From: Amanda Scholes on behalf of Planning.Responses
Sent: 09 November 2017 08:57
To: Planning Scanning
Subject: FW: Planning Consultation on: BE/113/17/RES

Comment from Greenspace

APPLICATION BE/113/17/RES

Site Address: Land West of New Barn Lane Bersted

scheme: Land West of New Barn Lane, North Bersted
client: Linden Homes
drawing: Landscape Proposals
date: July 2017
scale: 1:200@A1
drawing no: LIN21257 11C Sheet 1
drawn: LS checked: AE

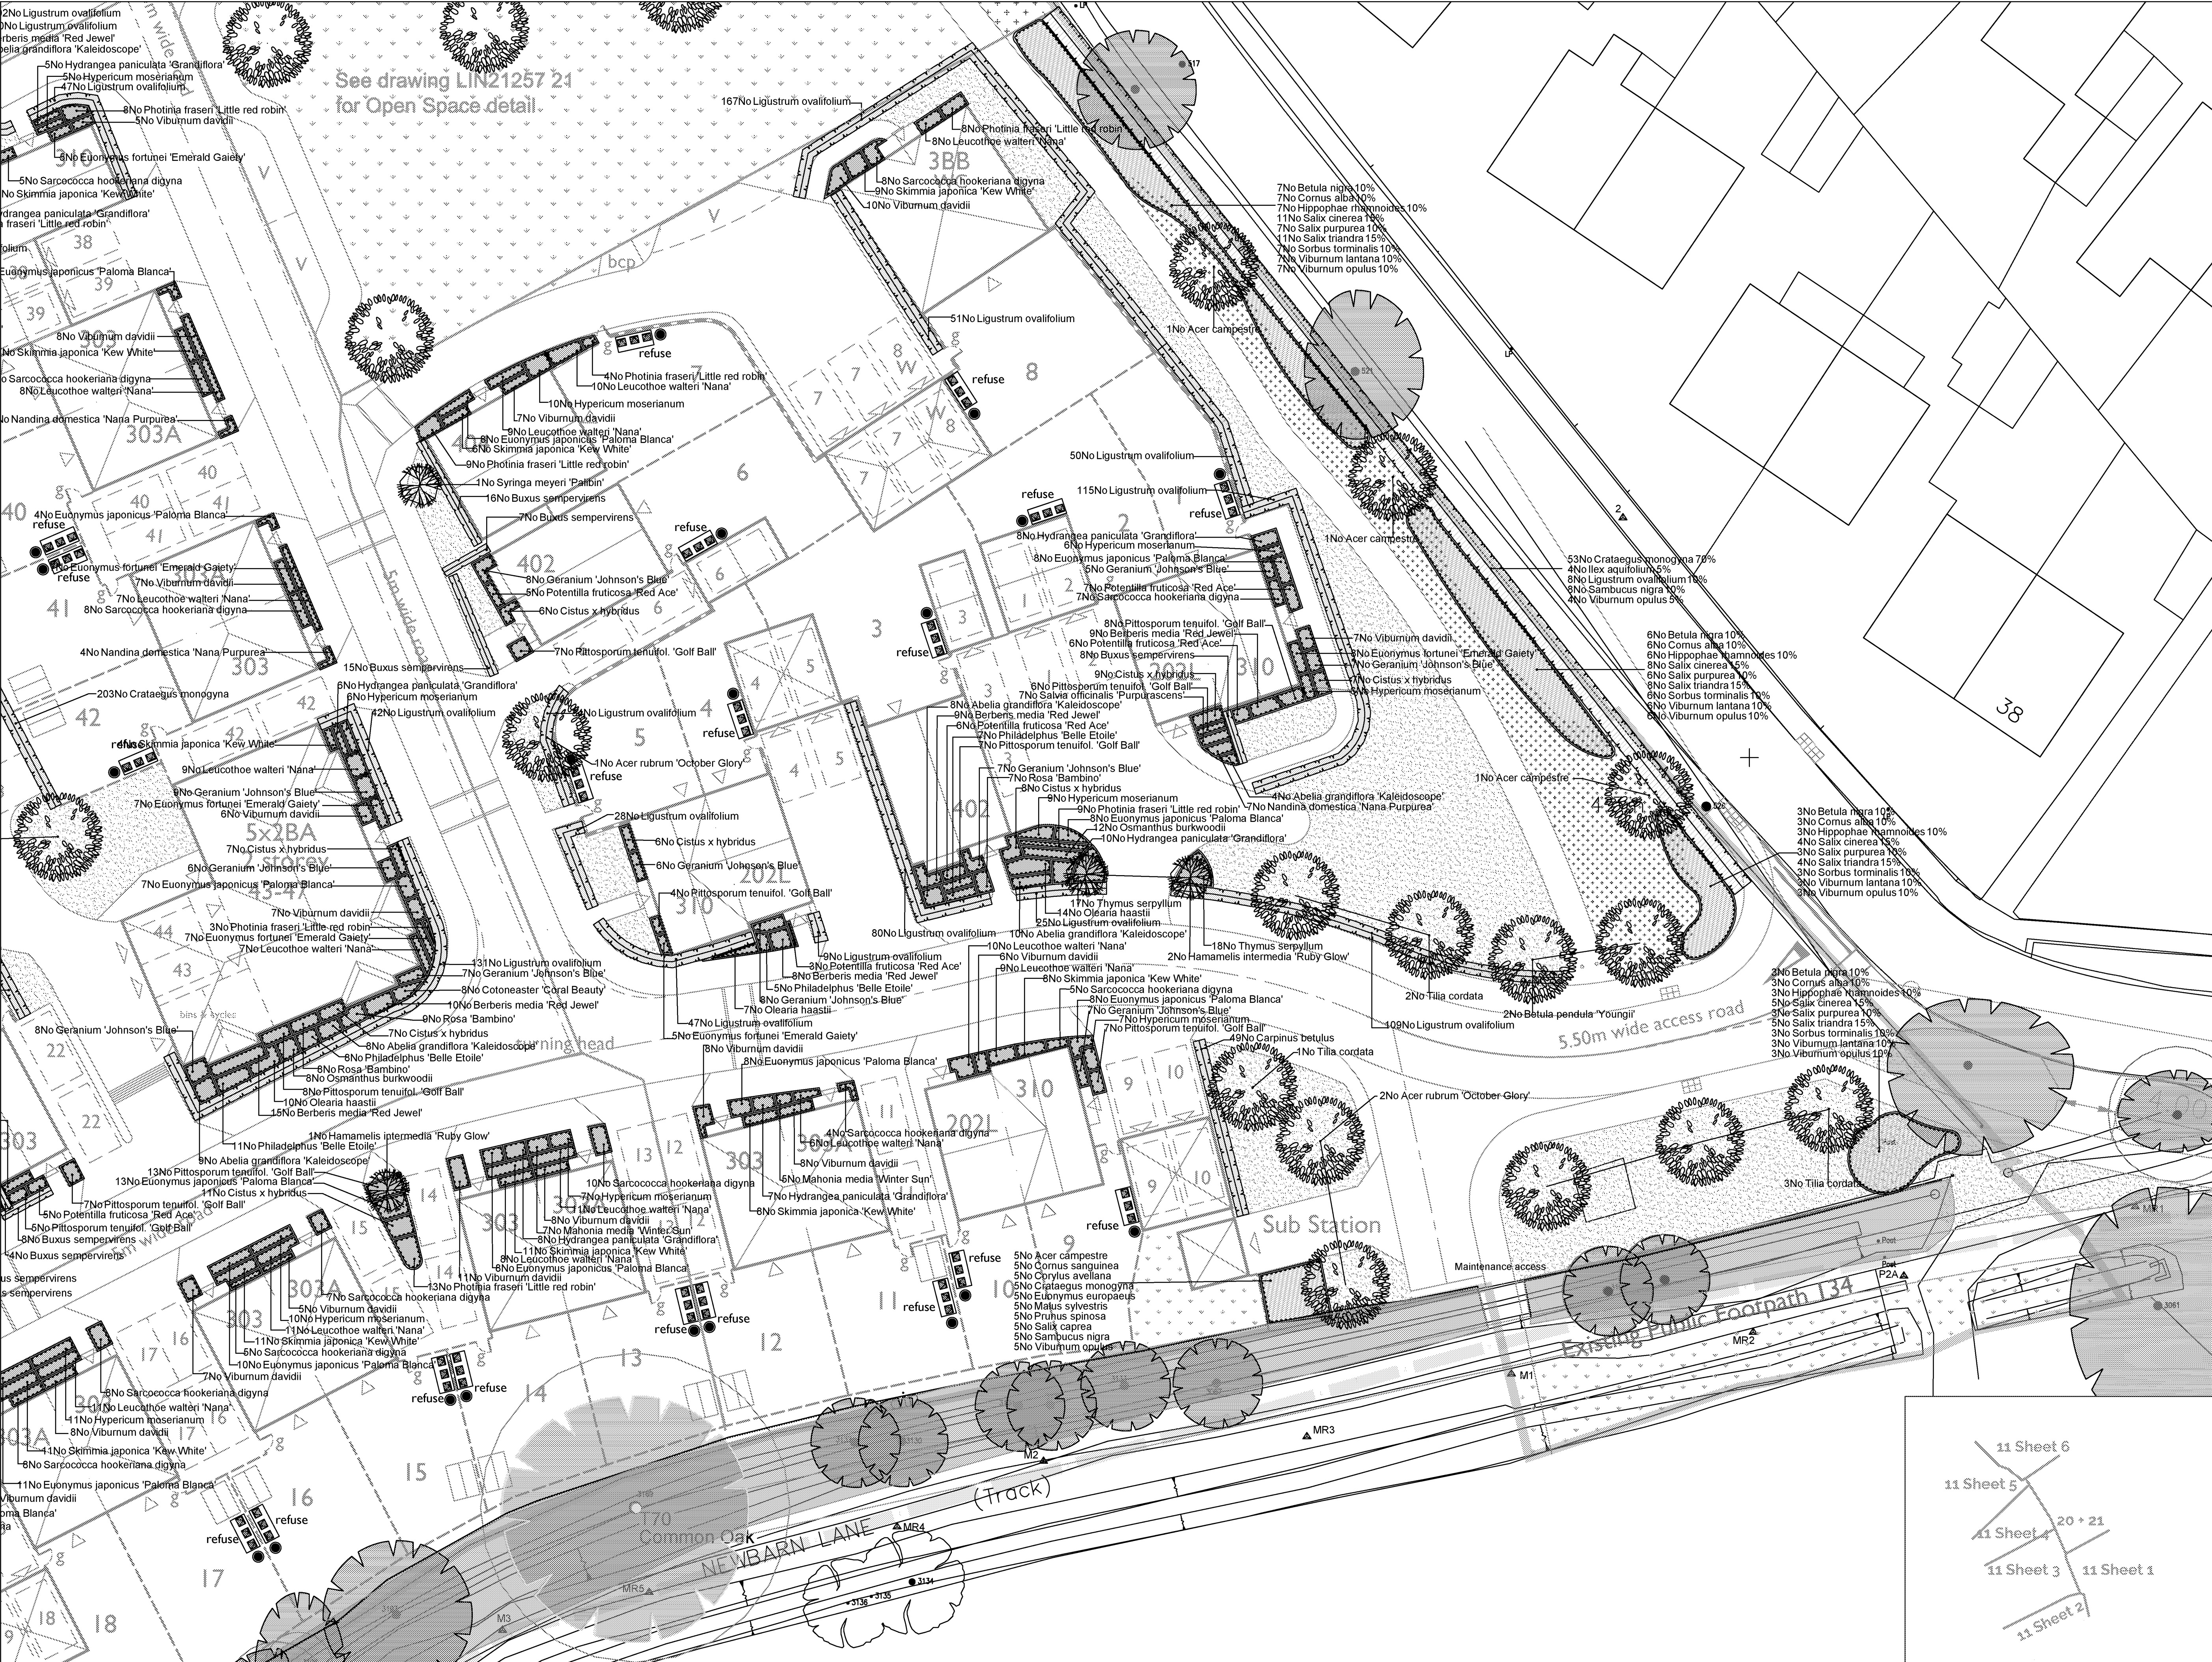
The play areas LEAP and 2 x LAP are now sited very closed to a detailed swale/water body. We would require clarification of the proximity of these to this drainage facility also to the depth of this indicated swale? The previously submitted detail indicated the main basin depth of 500mm, with 1000mm to the basin ditch only. The levels now shown would appear to indicate that this is now proposed to be significantly deeper than this with steeply angled sides? Please confirm the proposed levels of the swale, site sections sheet 2 16-1103-006 shows sections which stop short of this area, section E/E needs to extend through the play area and the proposed swale. Please also confirm the anticipated water holding period for this drainage facility?

The outline application BE/142/15/OUT showed the swale to a much lesser extent, the swale now equating for approximately half of the indicated open space proposed. Please confirm **the quantity of useable** open space now being provided within this development?

The indicated play areas are also dissected now by the swale which is not desirable as these play open space areas would not have easy connectivity. RoSPA should be consulted regarding the suitability of the play spaces in relation to this potential standing water body.

- Open space area proposed now significantly reduced by potential standing water body resulting in inadequate quantity of useable Public Open Space, confirmation of areas required.
- Cross sections required to detail the proposed depth of swale and proximity to play areas.

I would recommend an objection to the detail as submitted under application BE/113/17/RES and request that the above information and detail is submitted for clarification/amendment and approval.
